FW: ACP-324031-26: ESB Substation, Walterstown, Dunboyne (SID)

Report on Planning Application

Meath County Council
Planning Submission Report

Construction of 110kV Substation and Associated
Infrastructure in the townland of Walterstown,
Dunboyne, County Meath

Drawing Number
229101684-MMD-00-XX-DR-D-0200

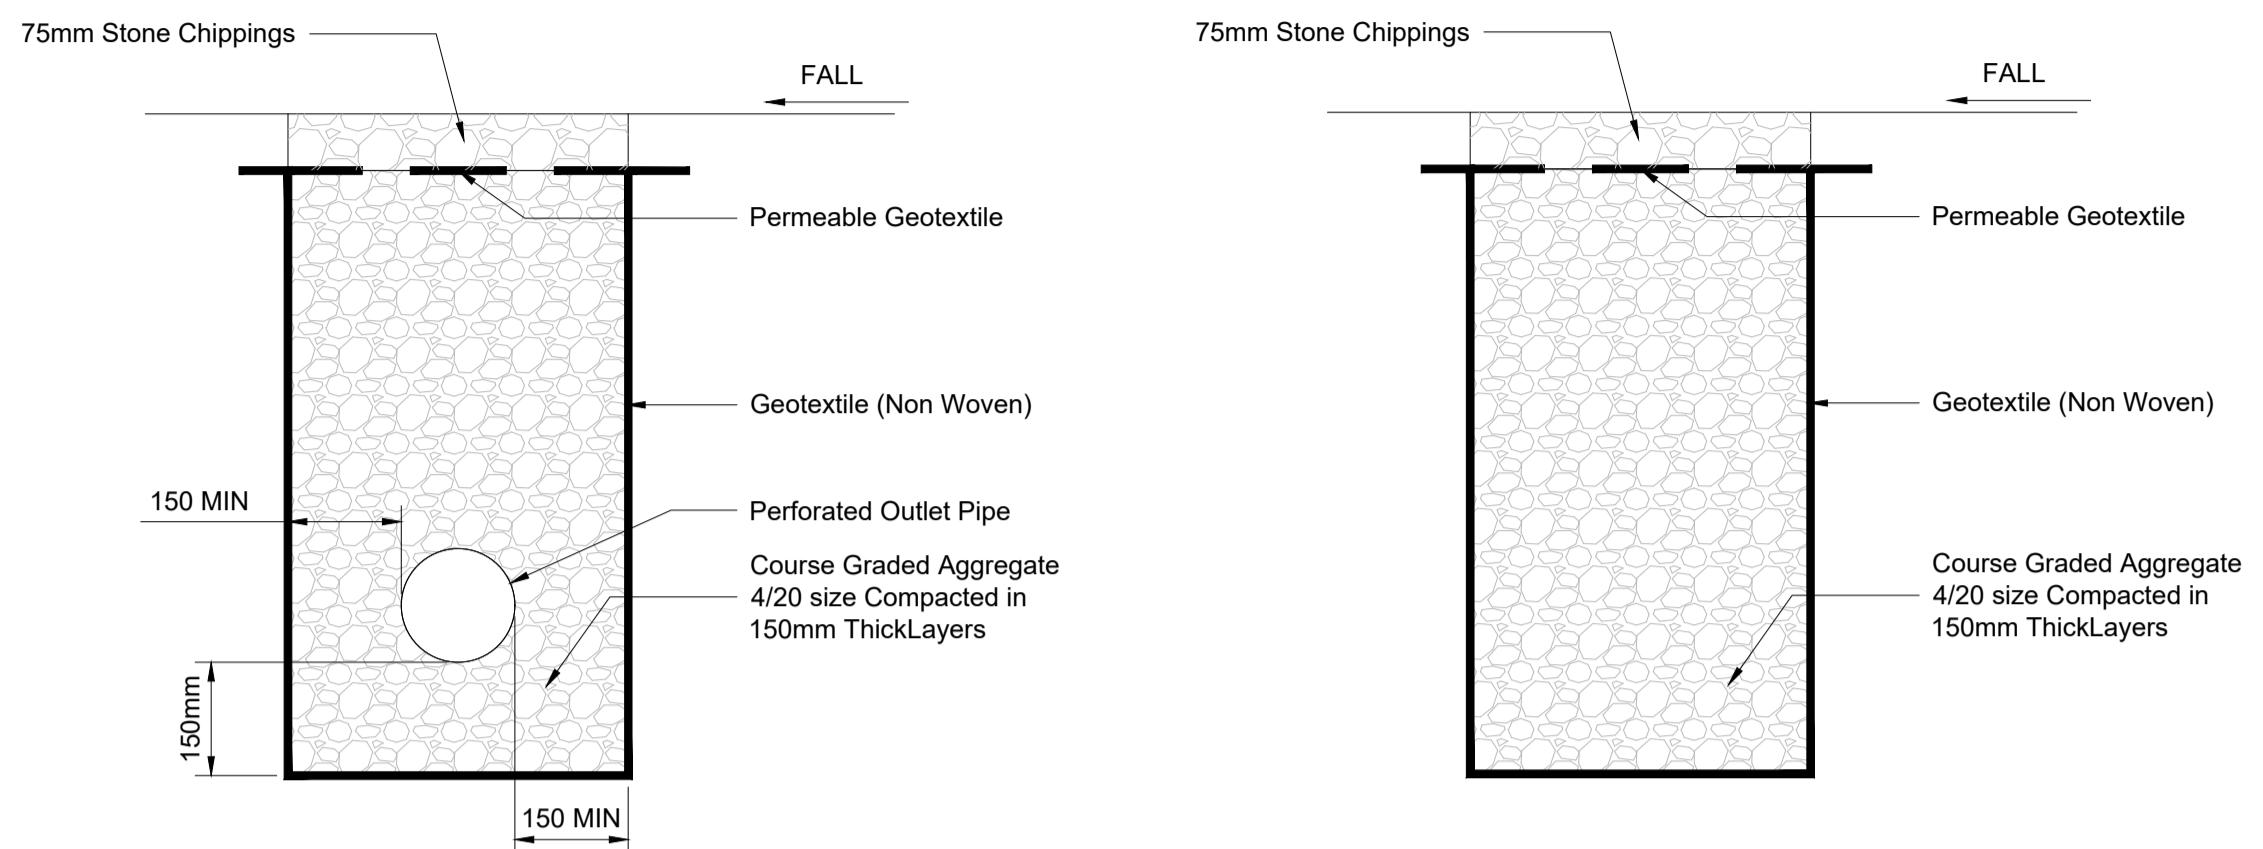
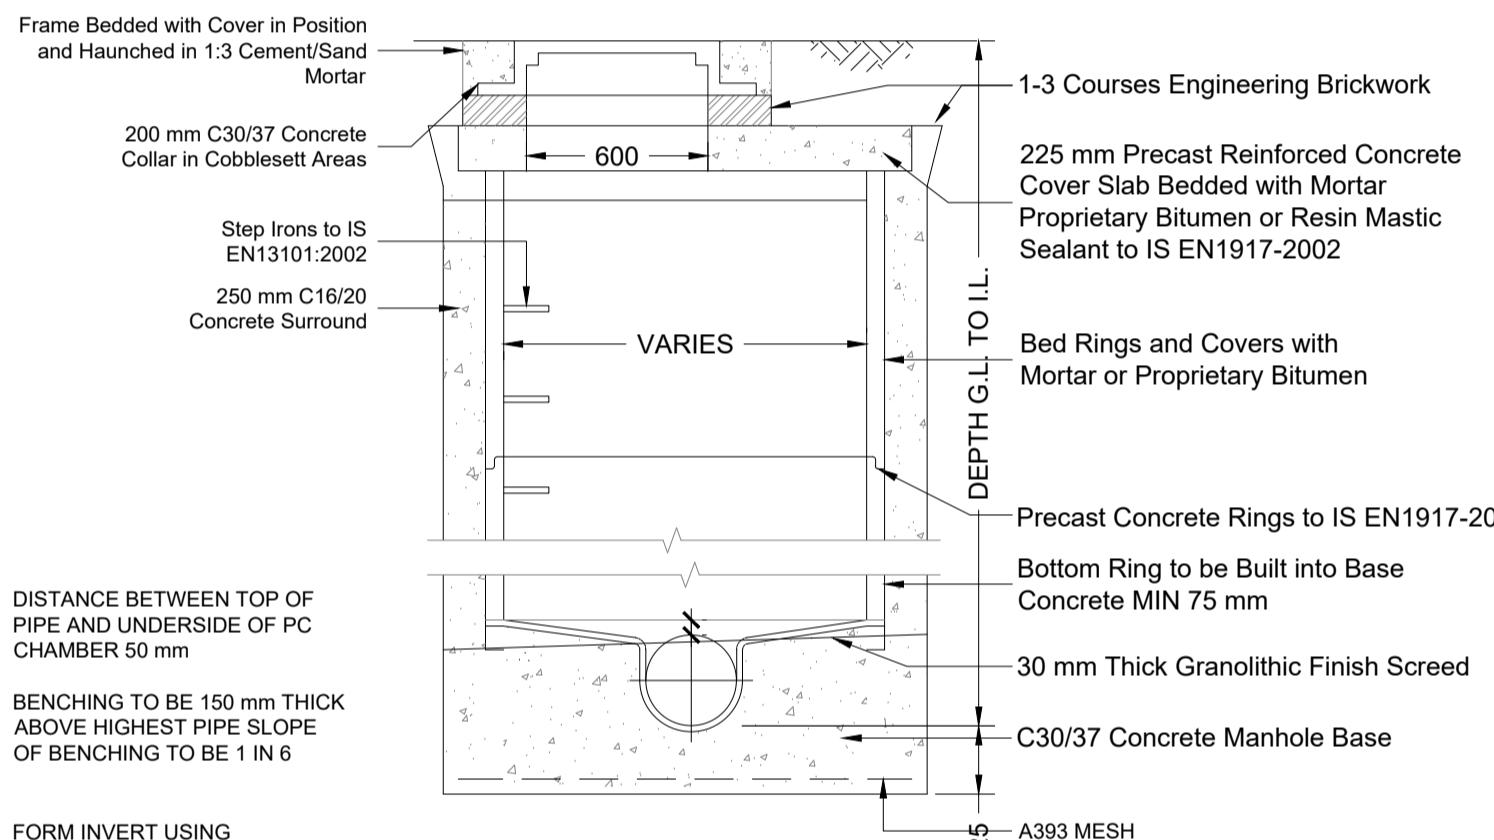
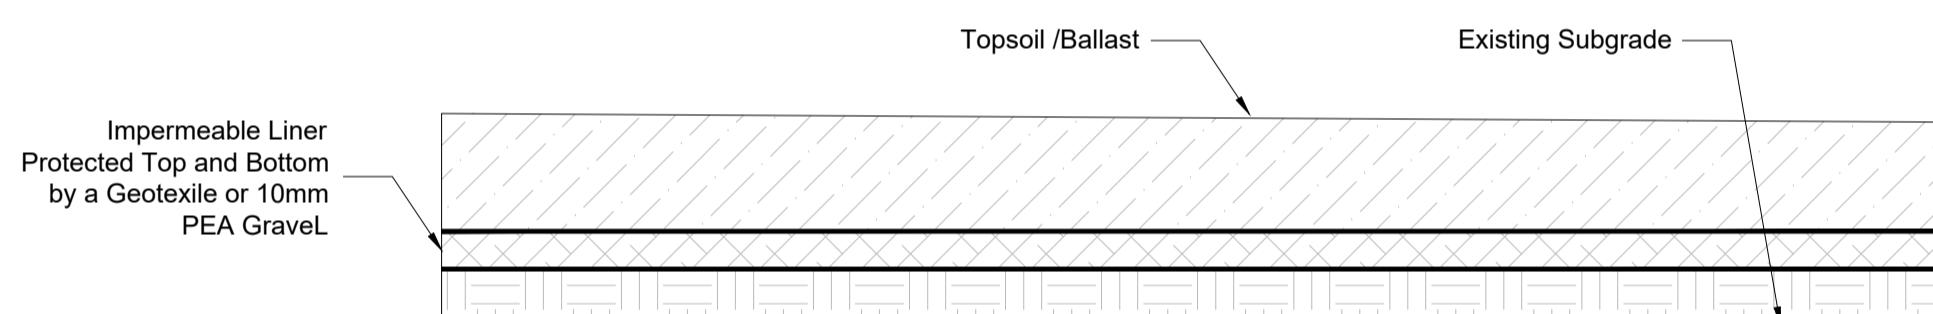
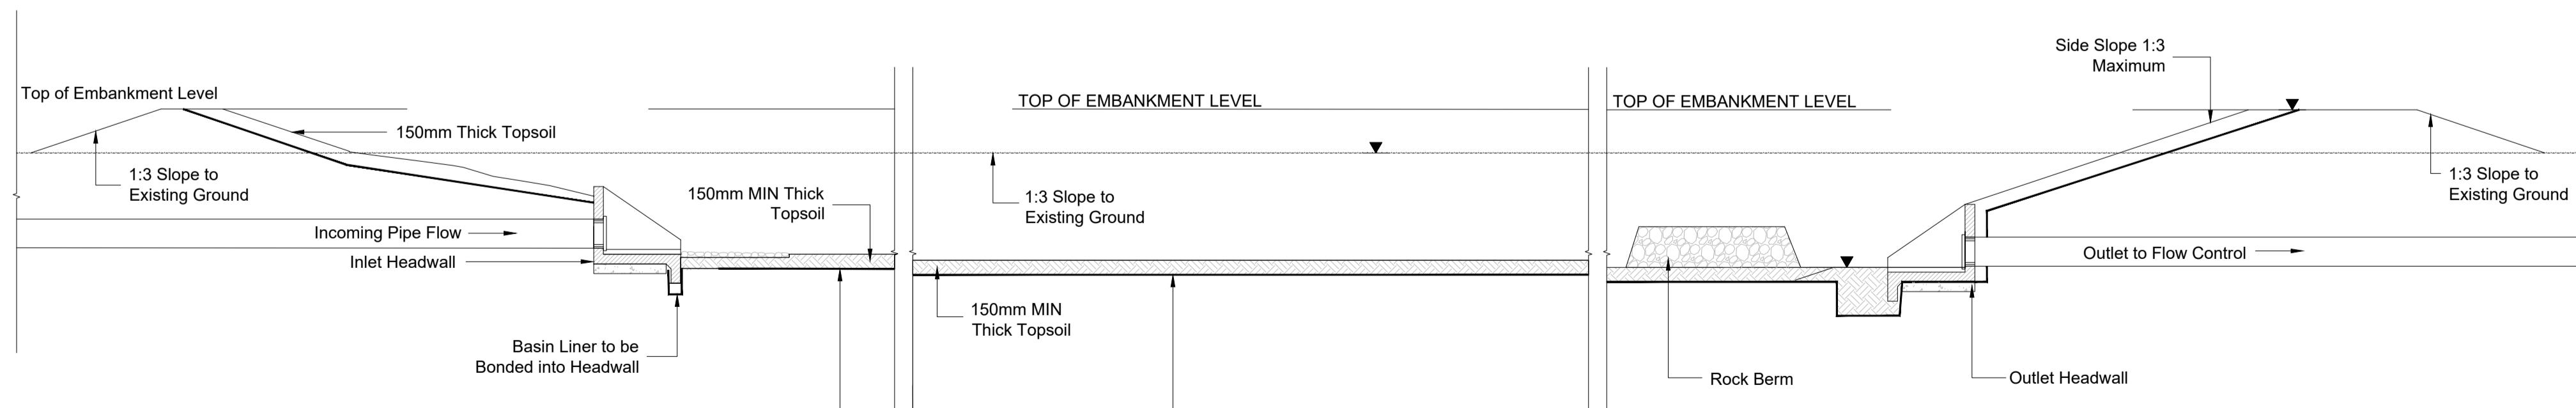
1. Prior to the commencement of any of the development on site, the applicant shall agree in writing with the planning authority a revised surface water drainage system that is SuDS compliant
